Littlehampton – LU/212/17/RES

Response to consultee comments in blue:

Tree Planting Details LA108

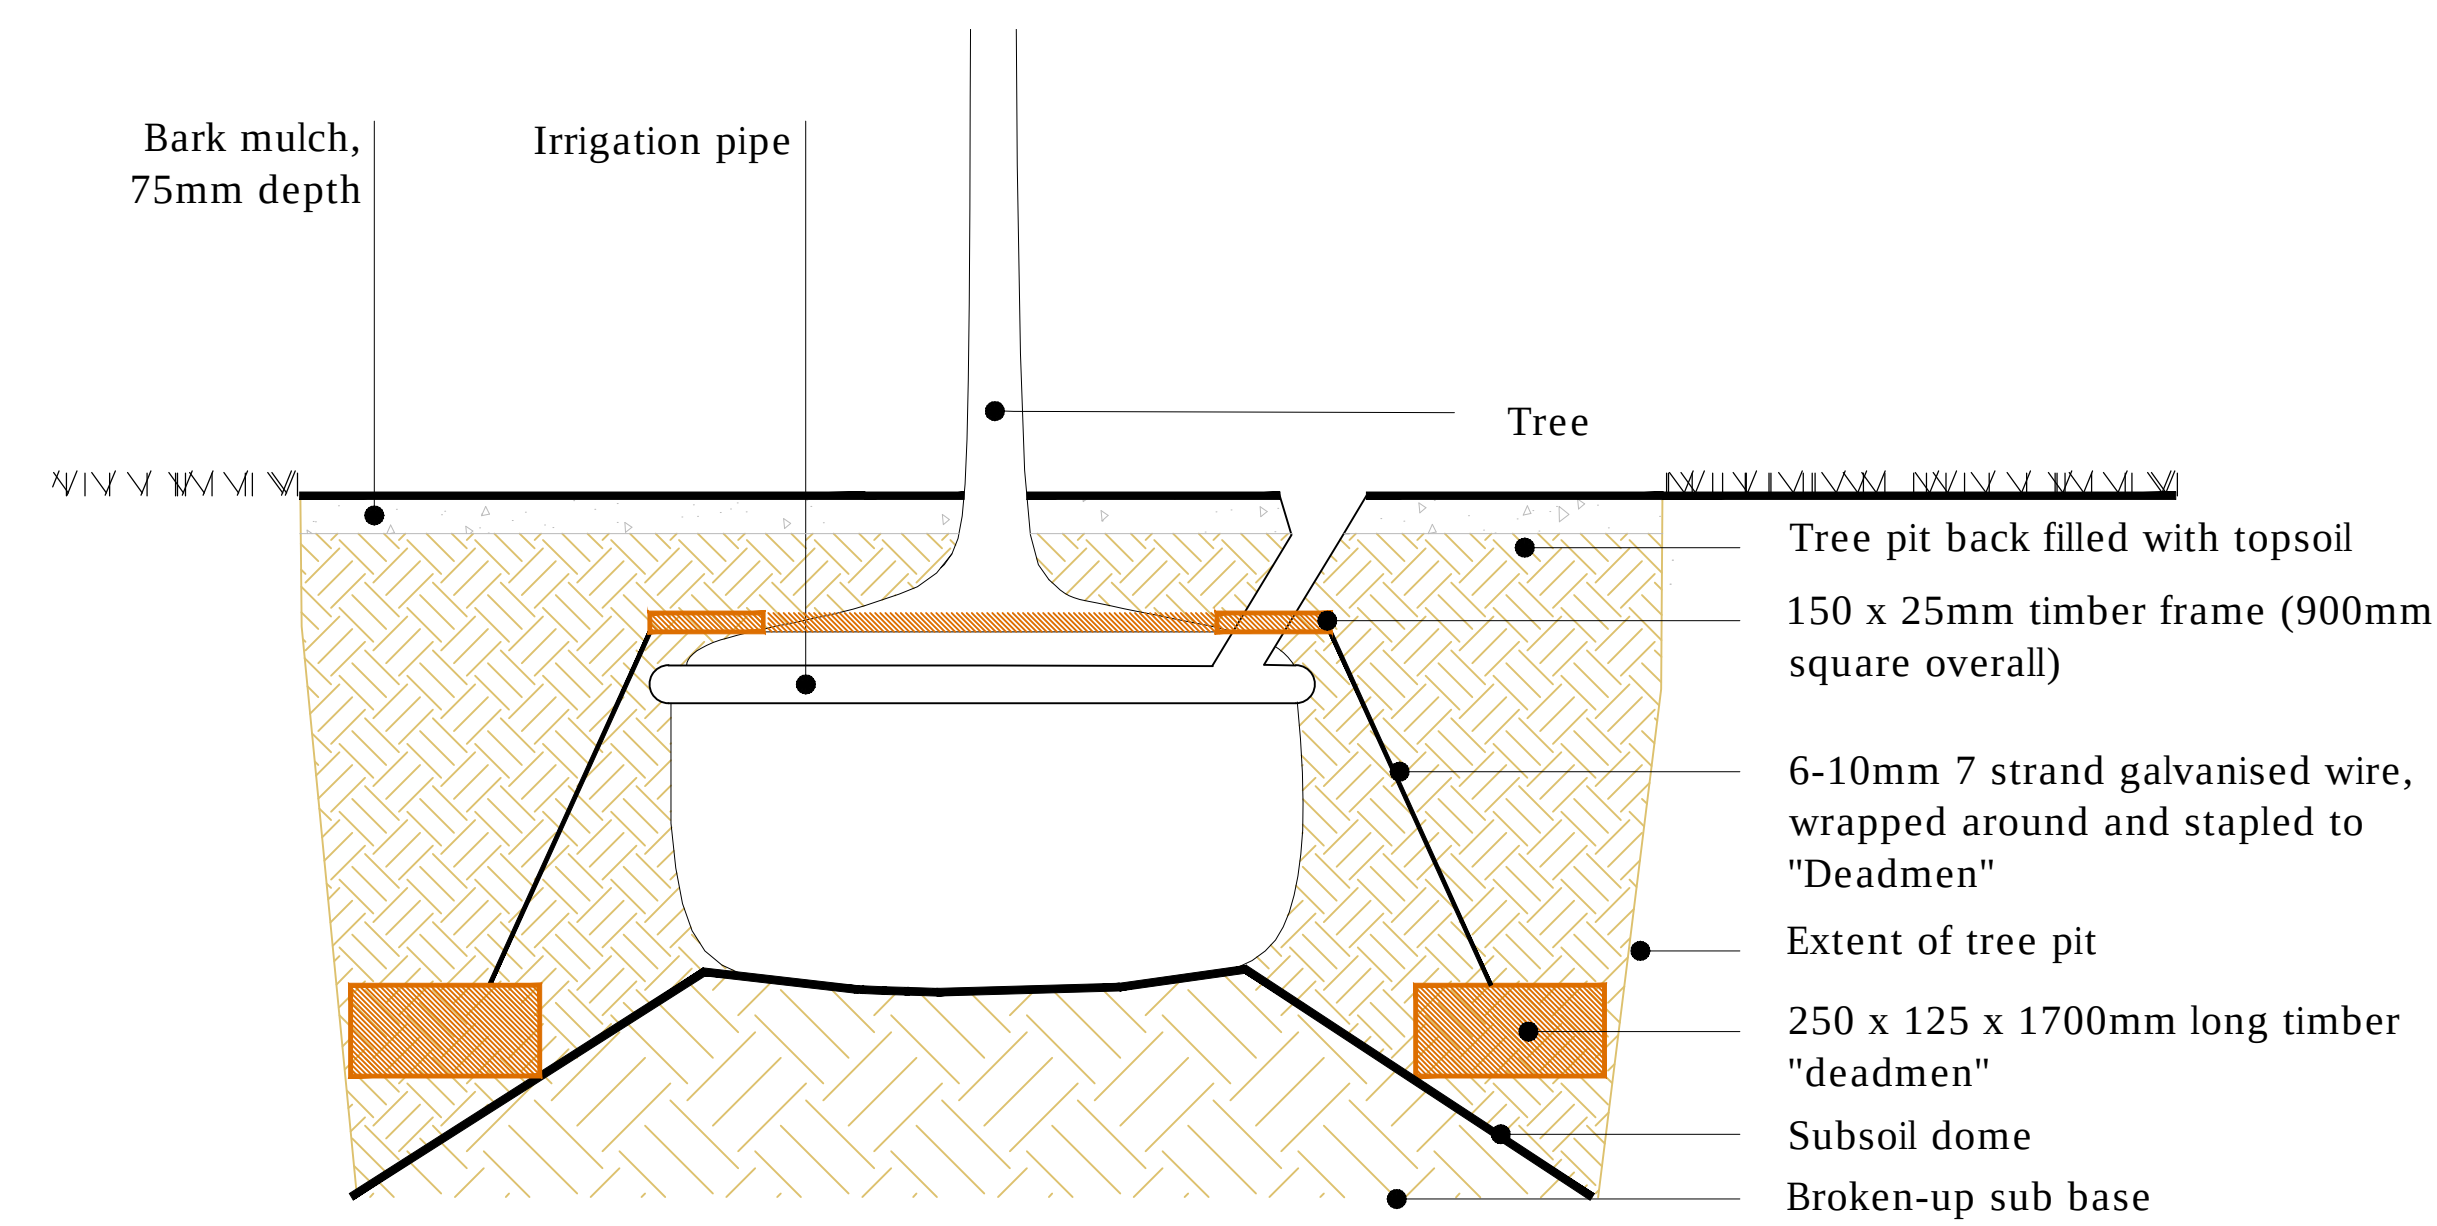
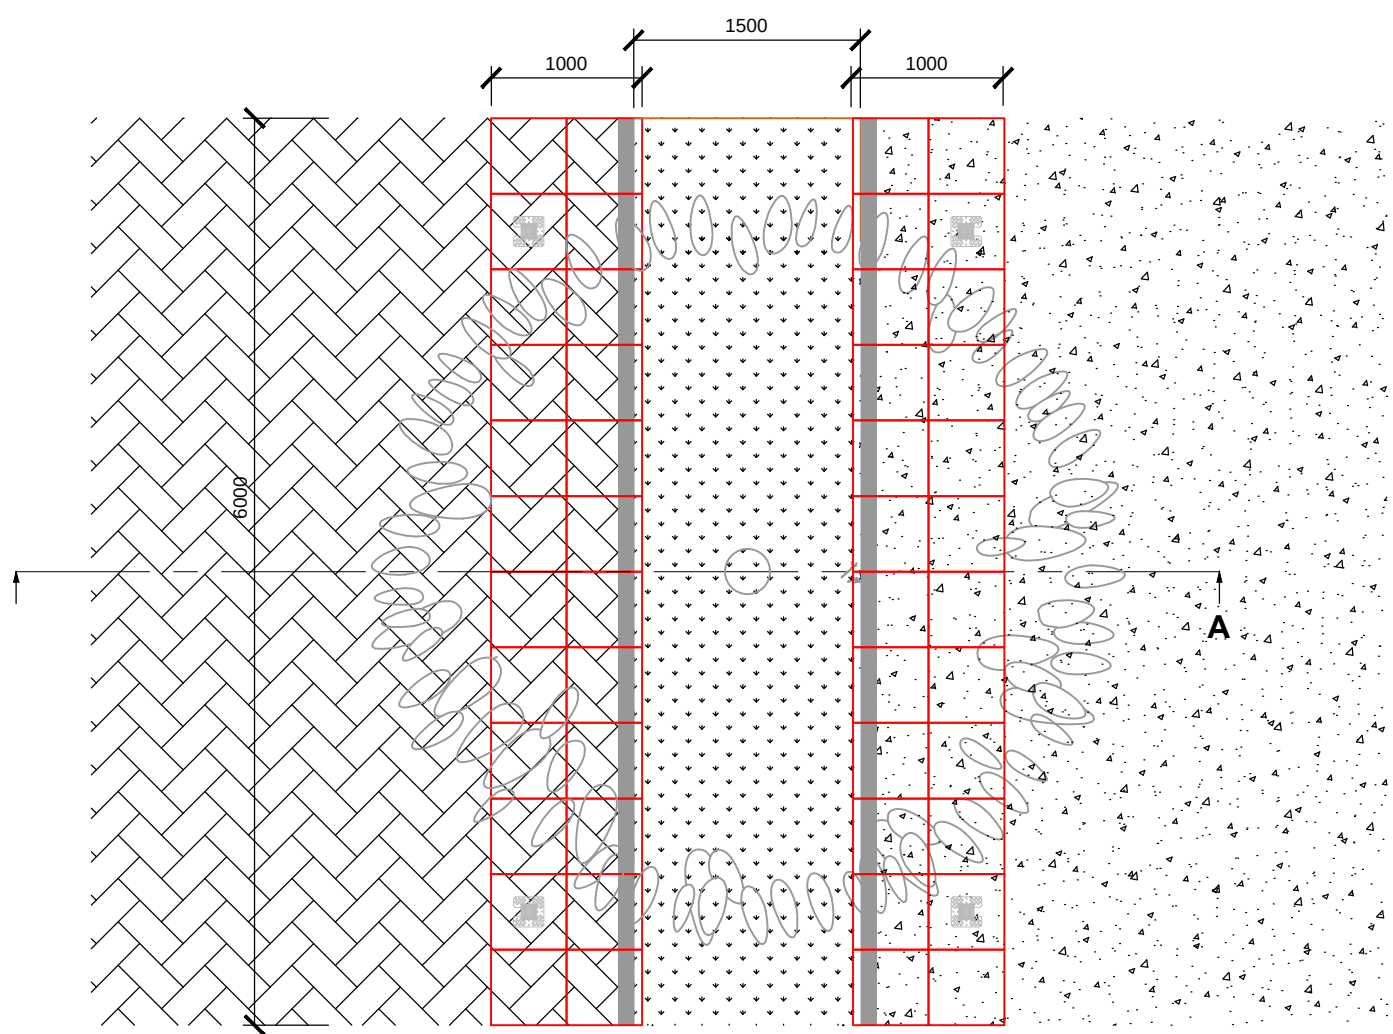
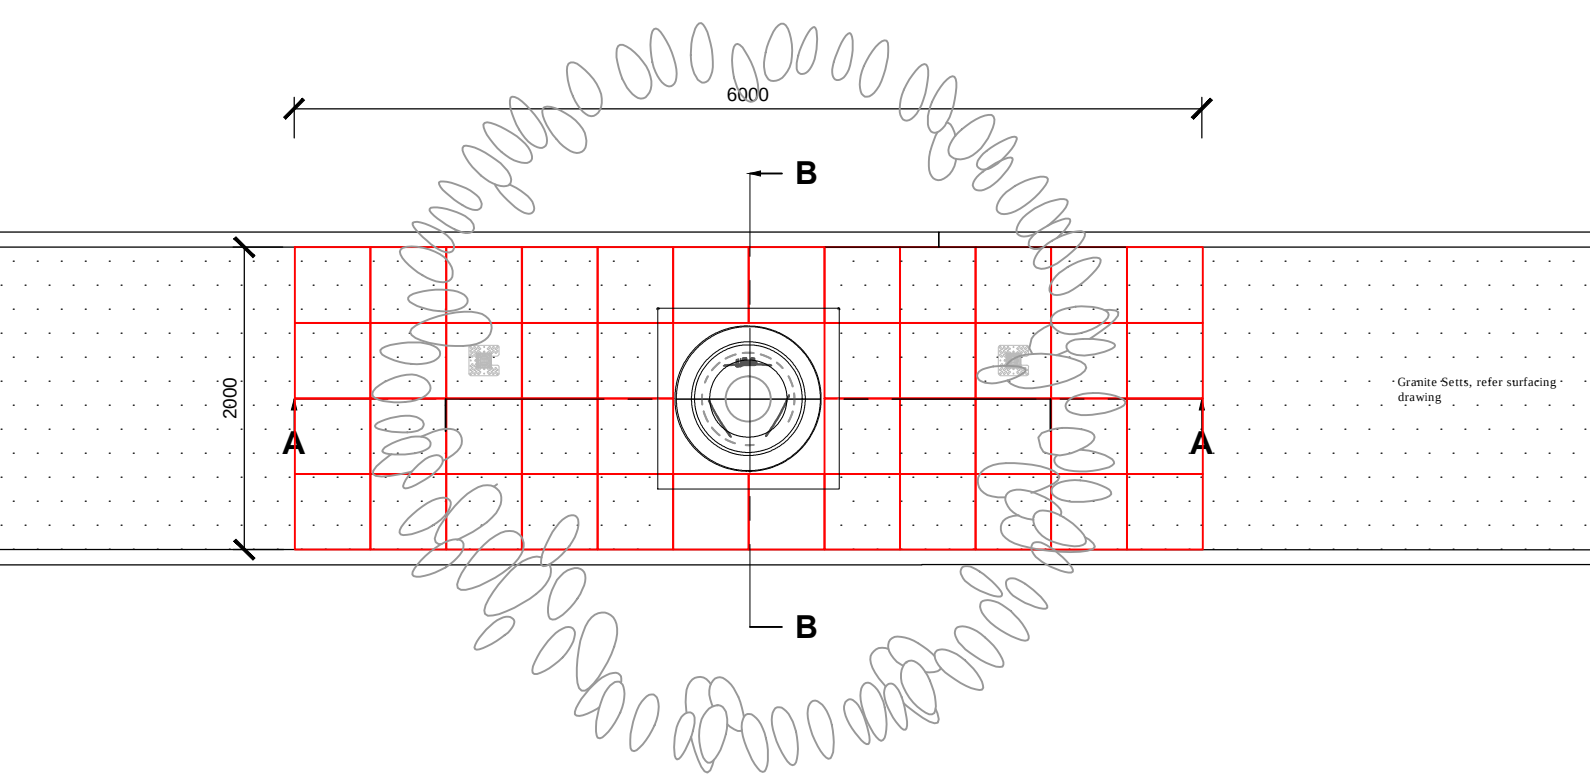
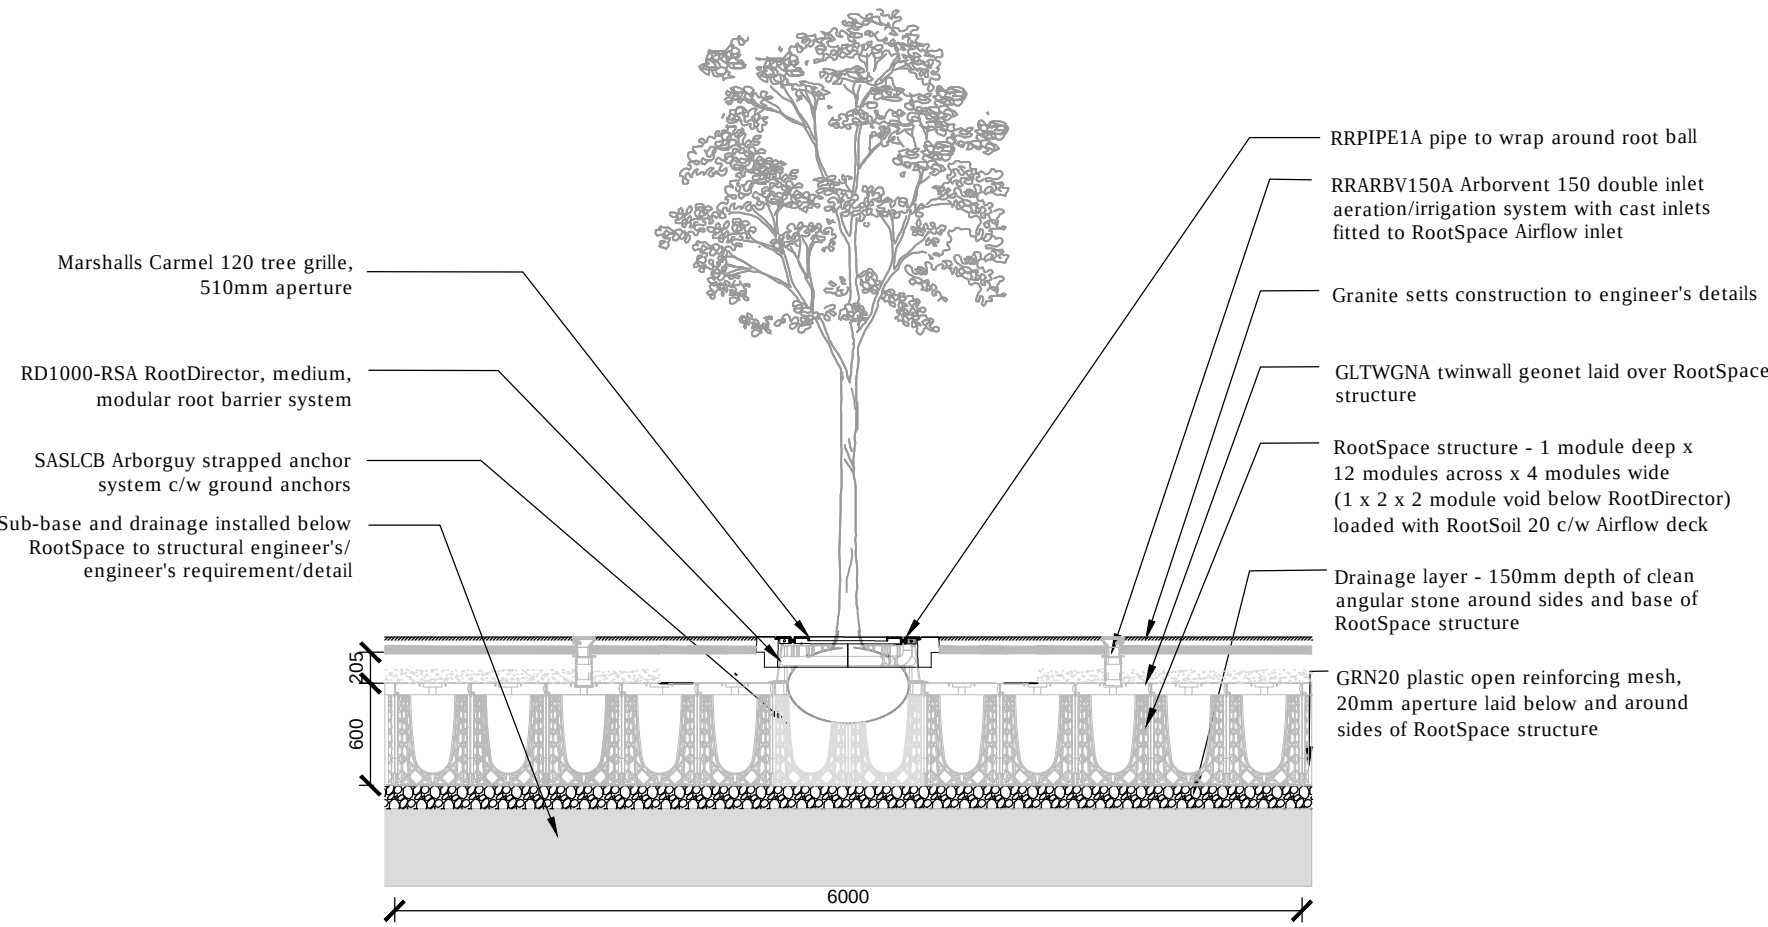
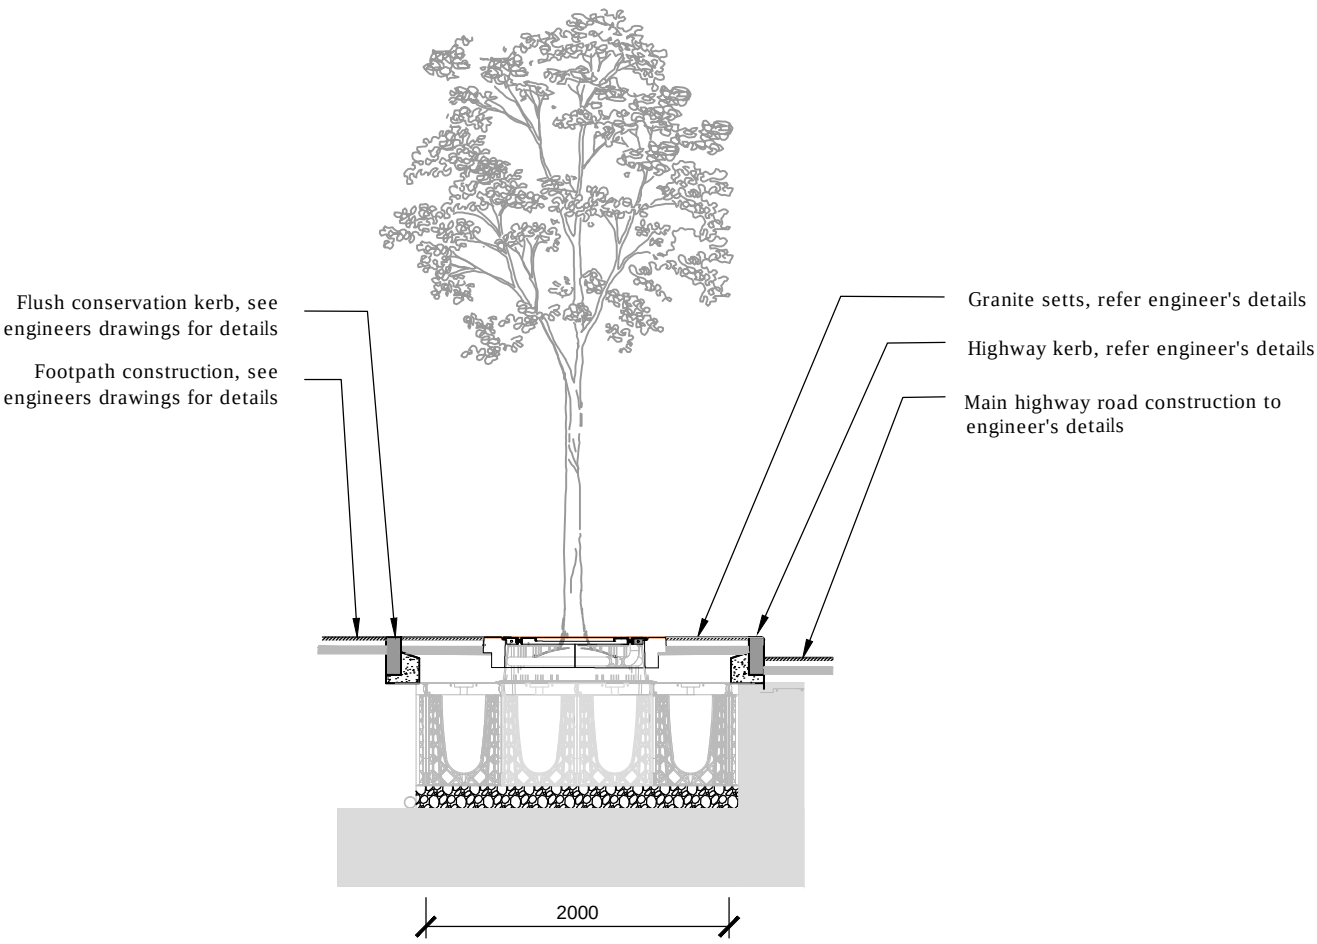
ADC Tree Consultant	
No objection	
ADC GreenSpaces	
(1) Also require a review of tree species choice and form in accordance with West Sussex Landscape. Frans Fontain would be a welcome species choice in this area. (2) Planting pit formation cross section and specification required. (3) Confirmation of who will be responsible for maintenance.	(1) Noted. (2) Noted. (3) The management company that has been established for the site. (4) Noted– suggest fenced. Landscape drawings to be amended accordingly. NOTE – the above landscaping comments will be reviewed and accommodated on revised landscape
